From: Amanda Scholes on behalf of Planning.Responses
Sent: 15 December 2021 08:14
To: Planning Scanning
Subject: FW: Planning Consultation on: BN/147/21/OUT

Engineers Comments Regarding Surface Water Drainage

Application No: BN/147/21/OUT
Registered: 19th November 2021
Site Address: Land West of Fontwell Avenue Fontwell Eastergate PO20 3RX
Grid Reference: 494655 106139
Description of Works: Outline application with all matters reserved (except access) for the erection of up to 8 No. dwellings.. This application also lies within the parish of Aldingbourne.

Title
OUTLINE DRAINAGE STRATEGY

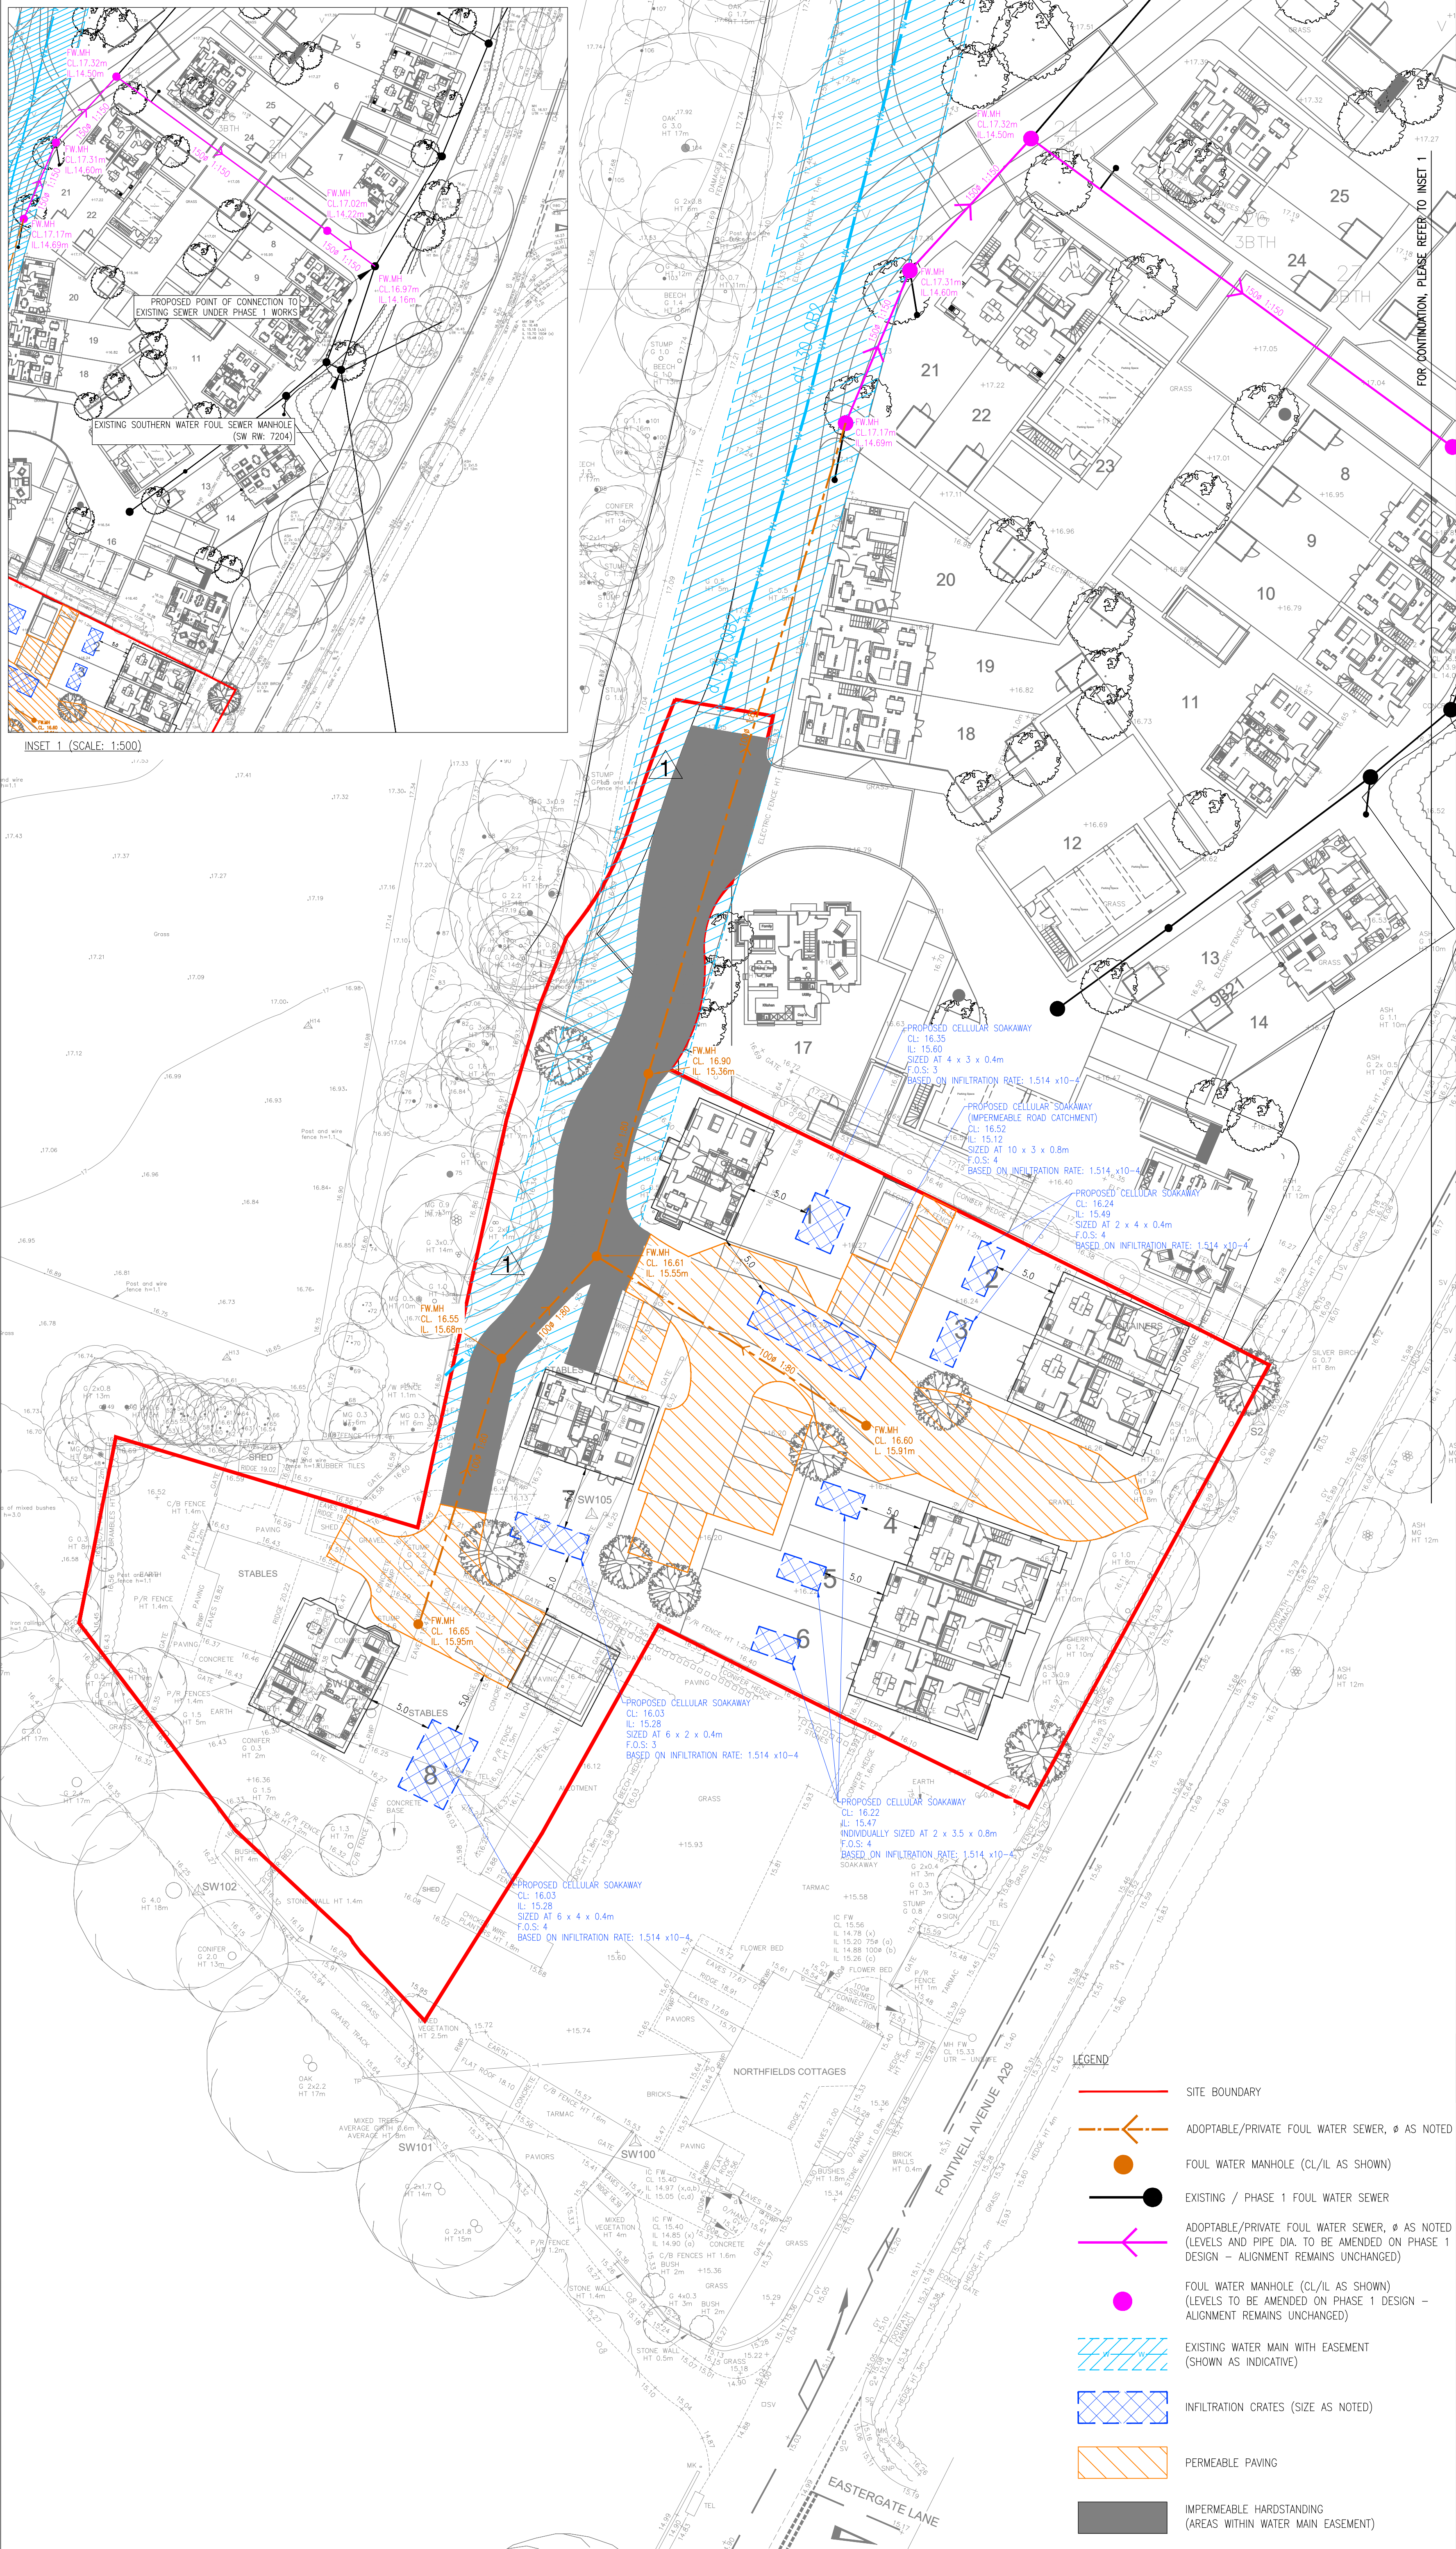
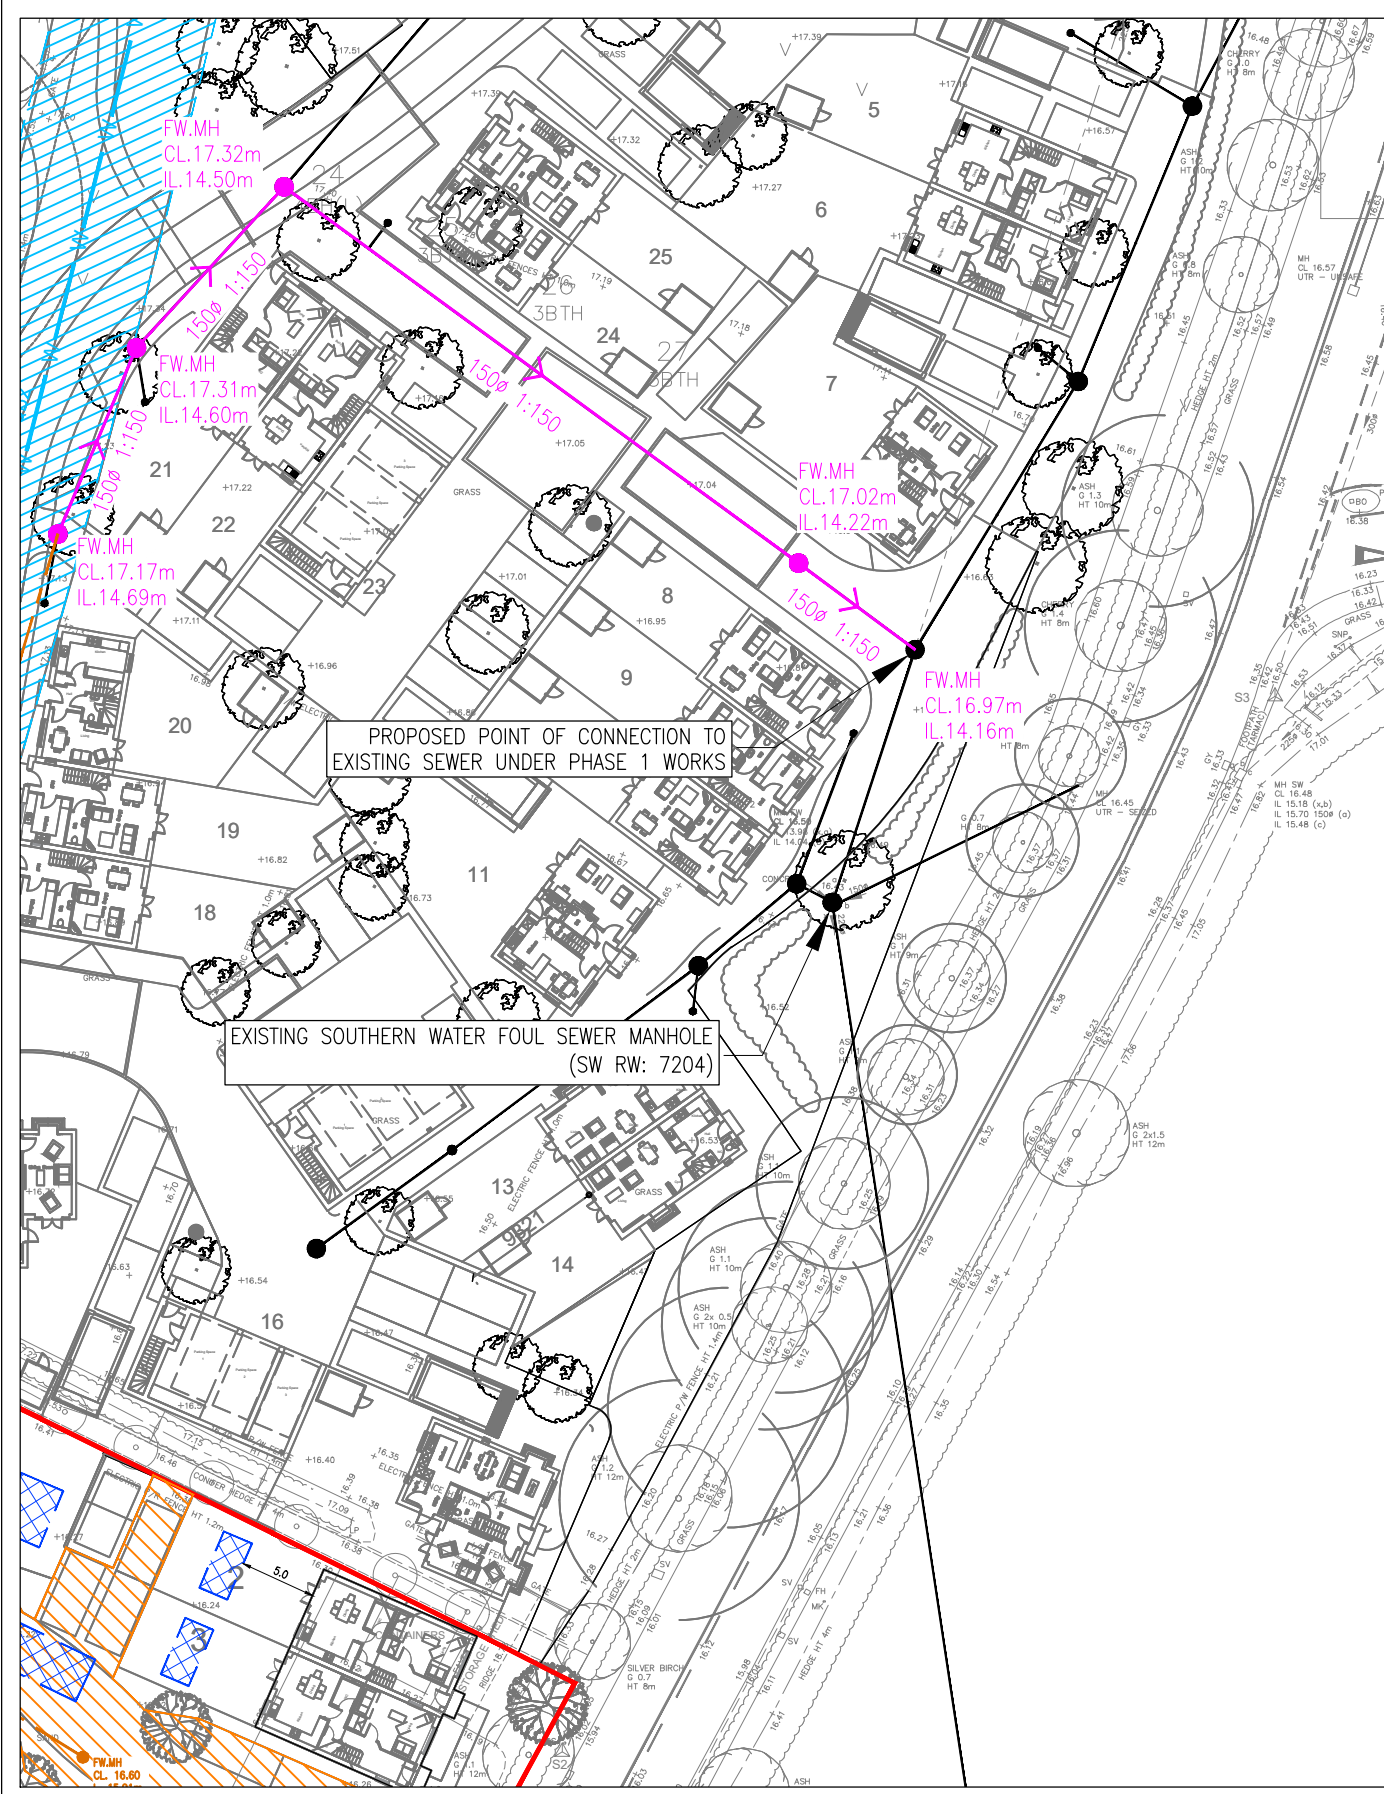
A surface water drainage strategy has been submitted with this application. This outlines that infiltration is proposed. The infiltration rates used in the strategy are based upon testing completed in October. We would remind the applicant that this does not constitute winter infiltration testing, and that further testing in the winter months will be required, along with winter groundwater monitoring.

Some of the cover depths to soakaways within the strategy are small, at discharge of conditions stage we will need to see that all soakaways achieve minimum cover depths as required by the manufacturer.
